Stage 1 Road Safety Audit Report

Mayo County Council

N58 STRADE RIVER BRIDGE REHABILITATION WORKS

Stage 1 Road Safety Audit

Purpose		PRELIMINARY ISSUE			
Title		Strade River Bridge MO-N58-001.00 Proposed Site Layout Plan			
Original Scale	1:250	Drawn	AGL	Checked	MG
		Date	03.01.25	Date	03.01.25
Status	S0	Reviewed	MJ	Authorised	MJ
		Date	03.01.25	Date	03.01.25
Drawing Number		0088572-ATK-02-XX-DR-CE-900203			
		P01

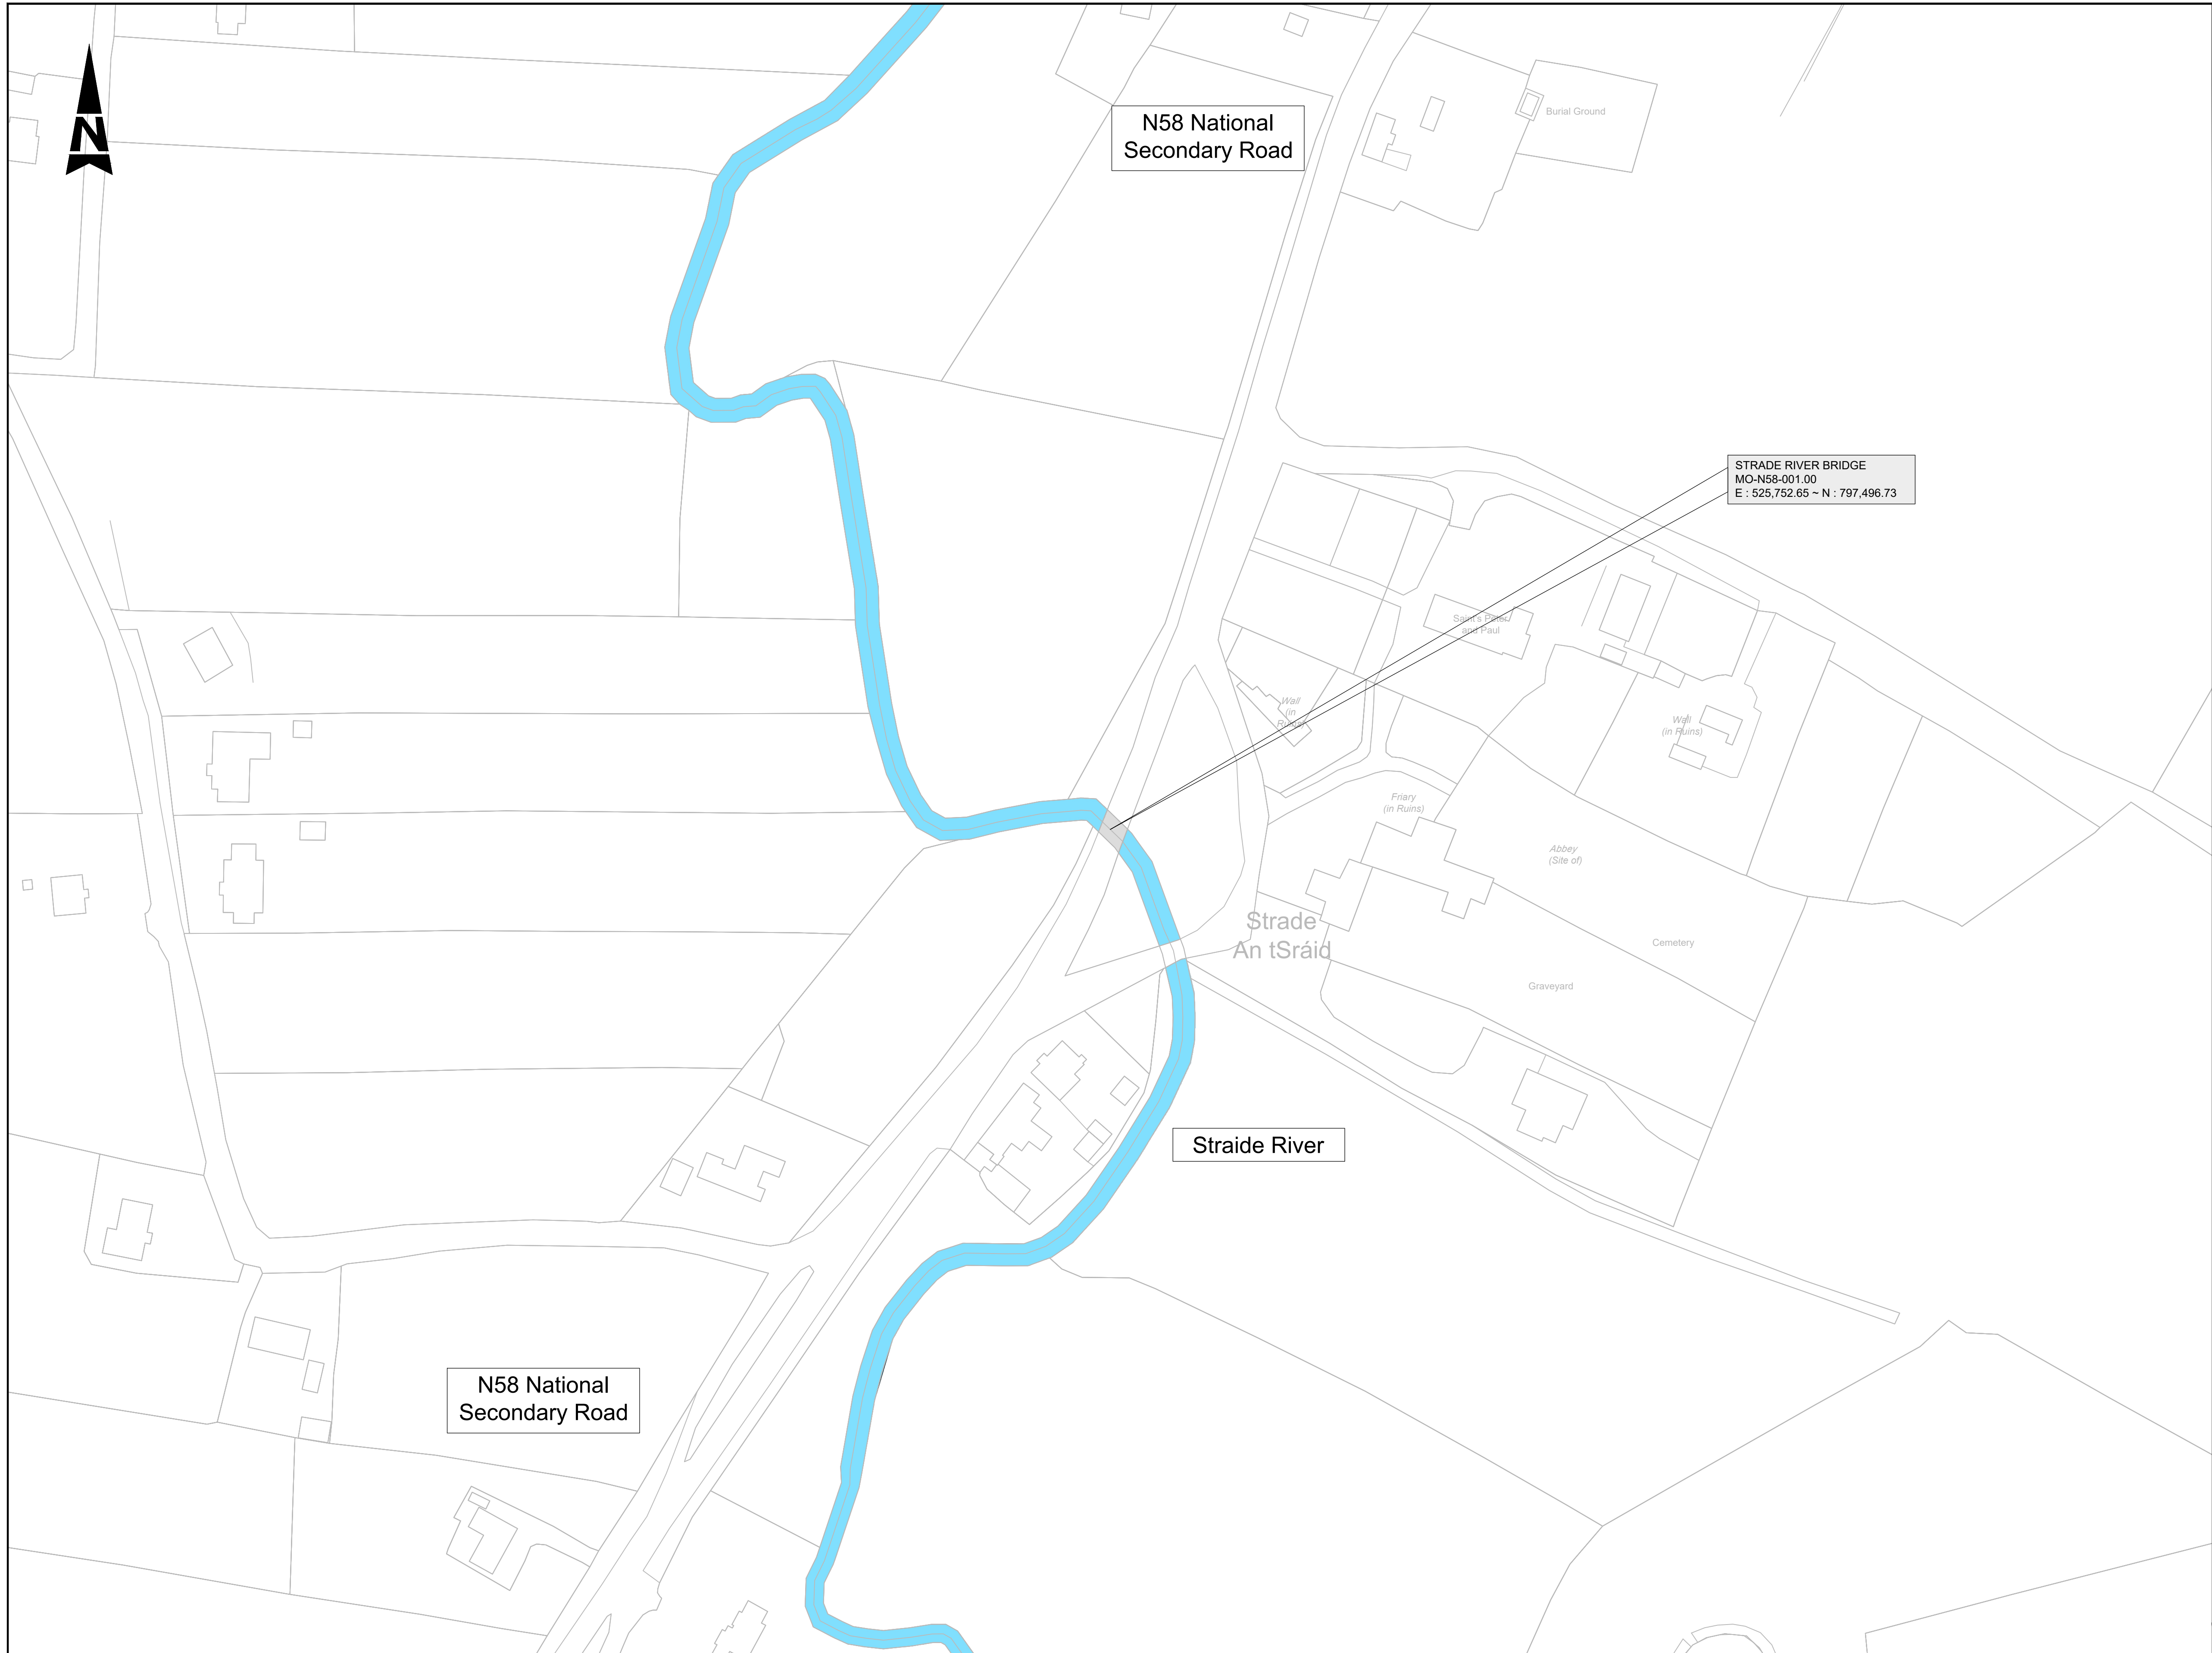
The proposed safety barrier may partially obscure drivers' sight lines at the Davitt Museum access, potentially increasing collision risks on the N58.

Assess sight lines at the access and adjust the safety barrier (if required) to optimize visibility.

| Problem Reference (Section 2) | Designer Response Section | | | Audit Team Response Section |
|----------------------------------|----------------------------------|--|---|---|
| 2.1 | Yes | Yes | Sightlines have been assessed with the ends of the safety barriers on the northwest departure and northeast approach to be flared to avoid impact on sightlines from the field access and the junction to the museum. | Noted. |

The Davitt Museum sign could be positioned within the barrier's working width, which may compromise the barrier's ability to deform correctly in the event of a vehicle impact. This could potentially increase the severity of a collision.

The position of the sign as it relates to the barrier should be checked, with appropriate adjustments made to ensure that the performance of the barrier is not compromised.

| Problem Reference (Section 2) | Designer Response Section | | | Audit Team Response Section |
|----------------------------------|----------------------------------|--|---|---|
| 2.2 | No | No | The Davitt Museum sign is confirmed to be outside the working width of the proposed barrier. | Yes. |
